**Subject:** Rezoning Petition Review

**Date of Review:** December 28, 2022 (**Revised January 26, 2023**)

**Rezoning Petition #:** 22-117

**Location of Property:** Approximately 9.16 acres located on the northeast side of Old Plank Rd, east of Brookshire Blvd and west of Harland St.

REZONING PLAN
RZ.01

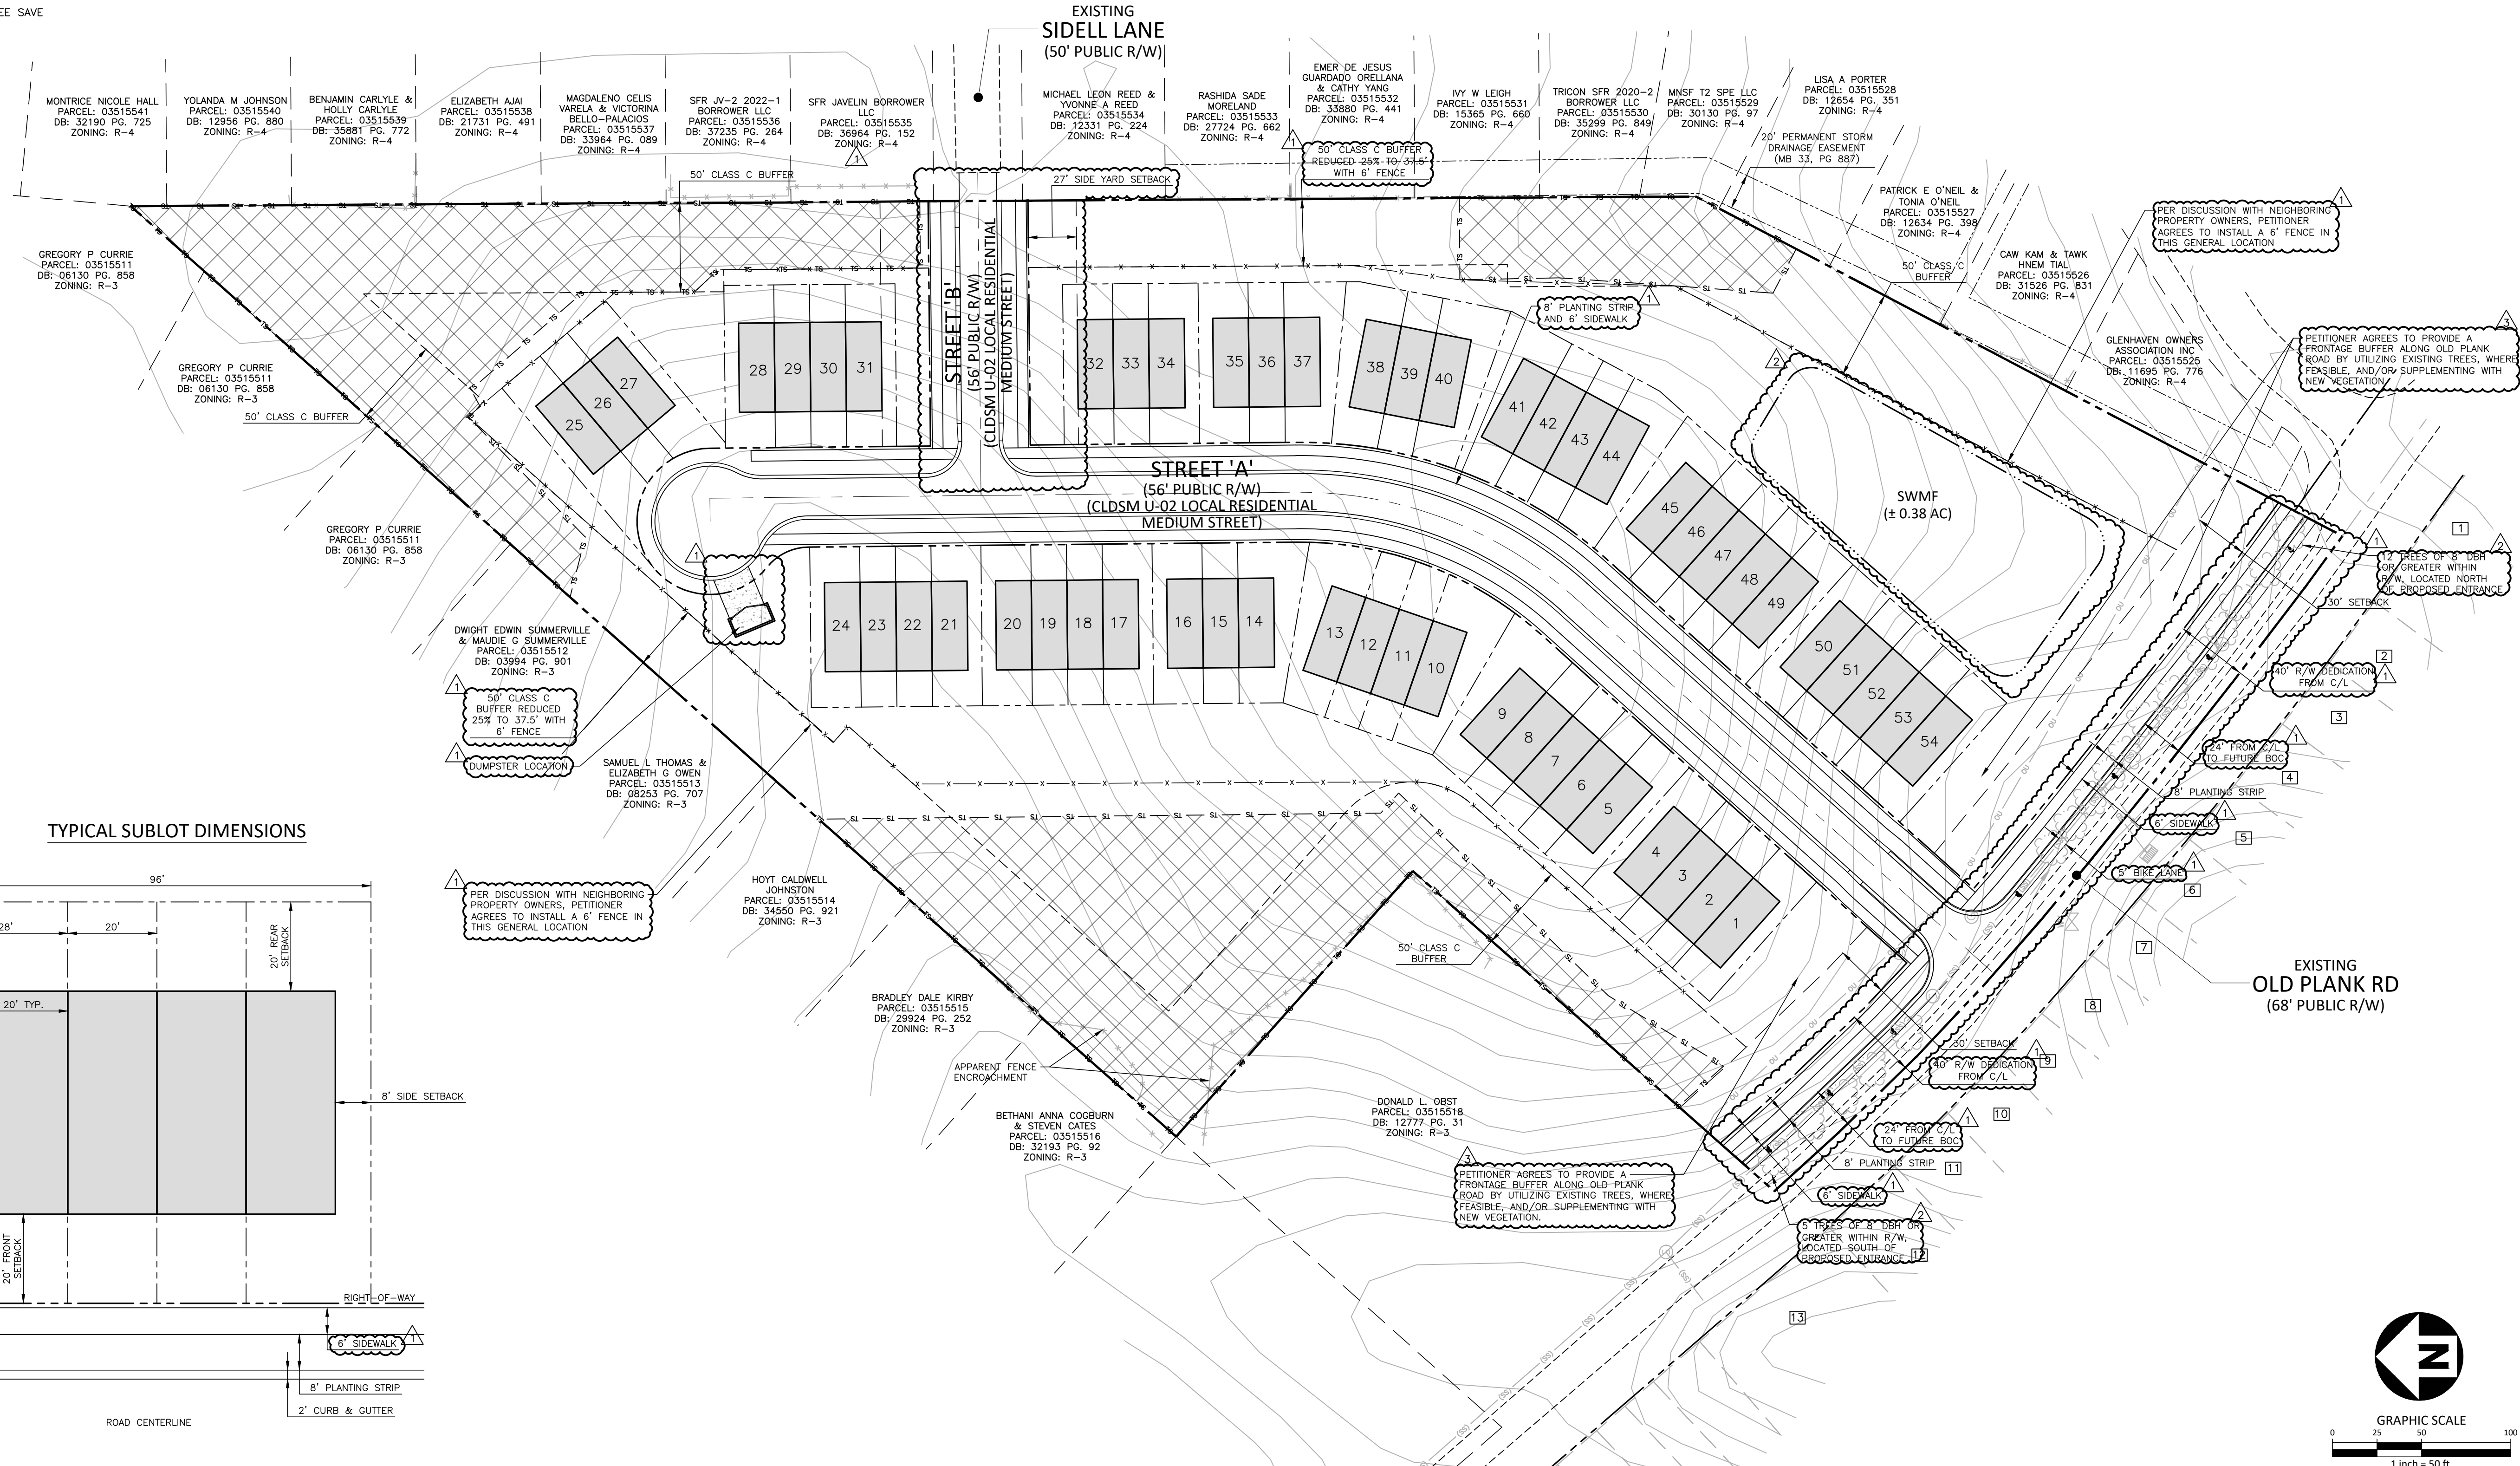
Please include the following note under Environmental Features. *For adjoining parcels receiving storm water discharge the petitioner shall analyze the adequacy of the existing storm water conveyance on the adjoining parcels to Sampson Street. If the existing storm water conveyance on the adjoining parcels is found to be inadequate, the Petitioner shall make a good faith effort with the property owner(s) to improve the storm water conveyance or mitigate the storm water discharge onto the adjoining parcels.*
